## City of Albuquerque Stormwater Construction Site Inspection Report

Project Name:		Maveriks Store # 611					
Location:		Unser & Los Volcanes Roadway					
Site Contact Name & Agency	Lance & Marcus			ESC File No.	K10E023D		
	<a href="mailto:msparling@sparlingconstruction.net">msparling@sparlingconstruction.net</a>			NPDES Id. No.	Unknown		
Inspection Date:	04/16/20	Start/End Time:	0830/1005hrs				
CoA Stormwater Inspector:		Timothy E. Sims					
Construction Phase:		vertical					
Type of Inspection:	x	Regular	Storm Event	Post Storm Event >0.25"	X	311/Complaint	Follow Up

ENGINEER'S SEAL  RONALD R. BOHANNAN P.E. #7868	MAVERIK STORE #NM-0115 UNSER AND LOS VOLCANES	DRAWN BY pm
	EROSION CONTROL PLAN	DATE 3-27-19
	TERRA WEST, LLC 5571 MIDWAY PARK PL NE ALBUQUERQUE, NEW MEXICO 87109 (505) 858-3100 www.tierrawestllc.com	DRAWING 2018042-SWPPP
		SHEET # SW-1 JOB # 2018042

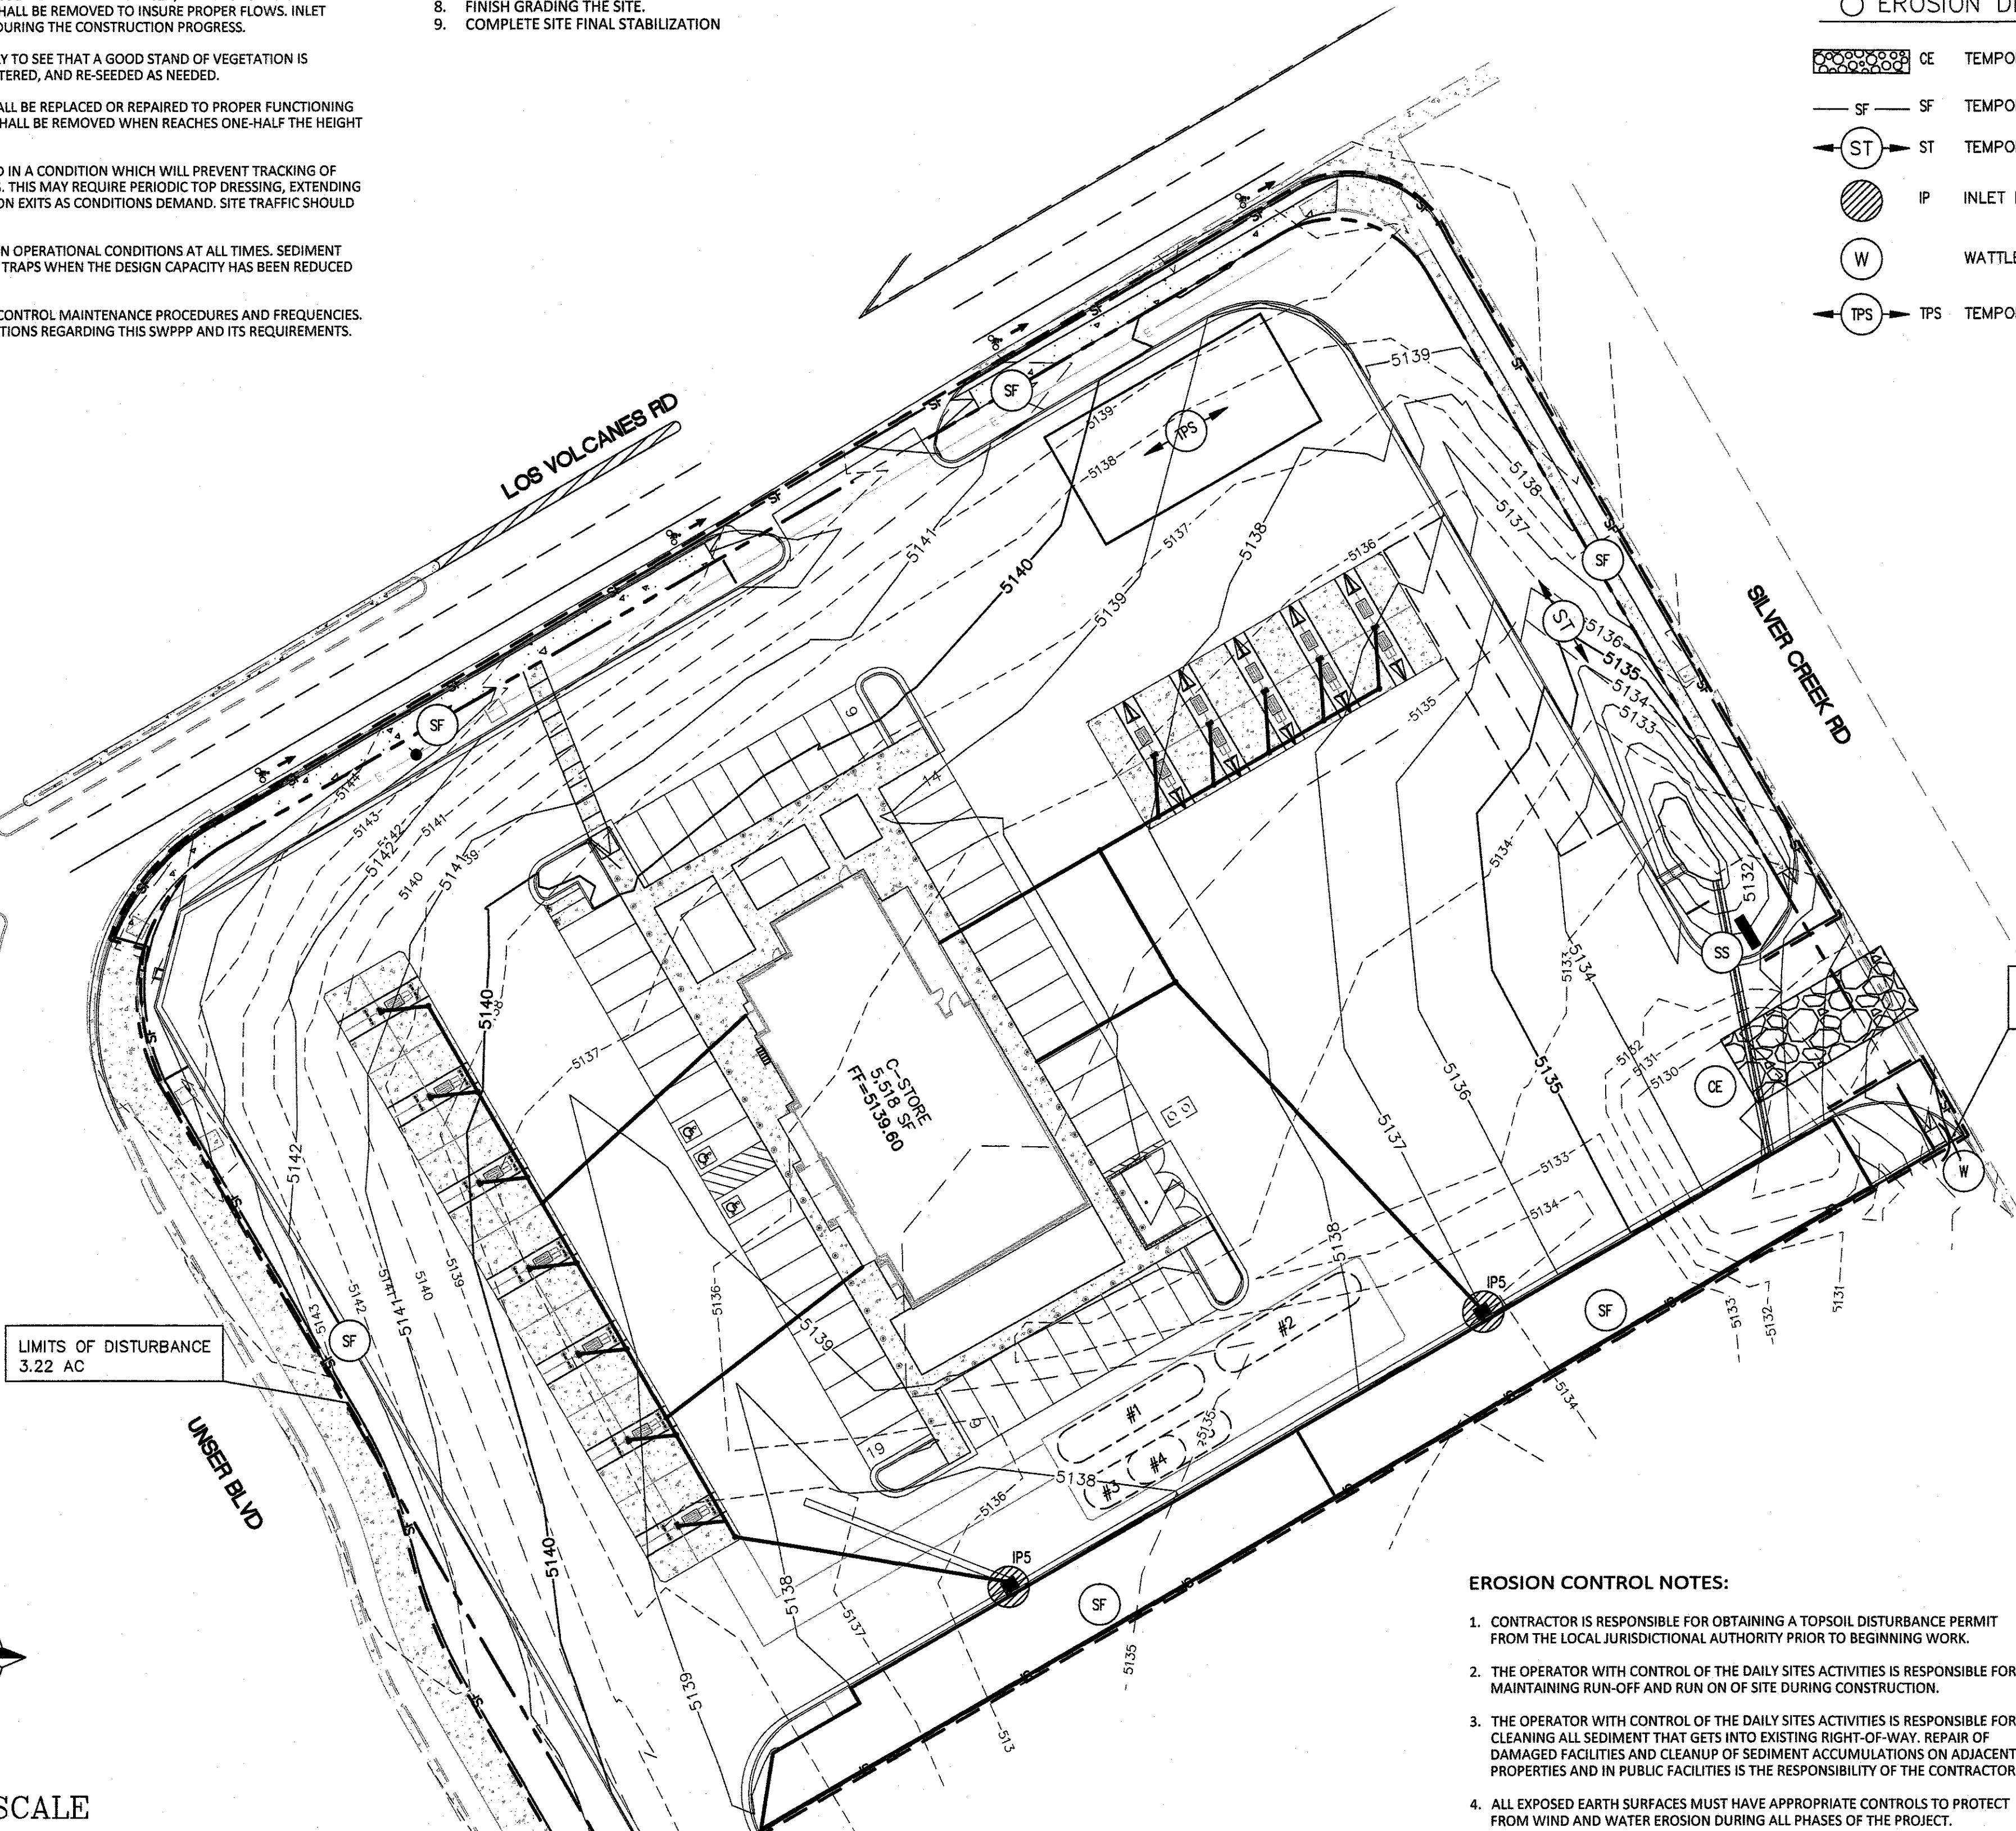
Item Number	Deficiency/ Corrective Action		
1	Remove all sediment from Los Volcanes on the north side of the roadway from 4701 to the intersection of Unser and Los Volcanes.		
2	Revise ESC plan to reflect work in Los Volcanes from Unser to E.O.P. The revised plan will need to reflect the work being completed on the south side of Los Volcanes and along Silver Creek Rd NW.		
3	Please provide the latest SWPPP self-inspection report for the work in Los Volcanes.		
4	Please provide Stormwater quality approval of revised plan.		
5	Provide N.O.I. or acceptance of of Owner's NOI and SWPPP program for site.		
	A rain event occurred on 04/13/2020. please provide required report.		
2.1	Discharge off site? (Y/N)	No	
4	Self Inspection Reports	requested	Latest report Date: not on file
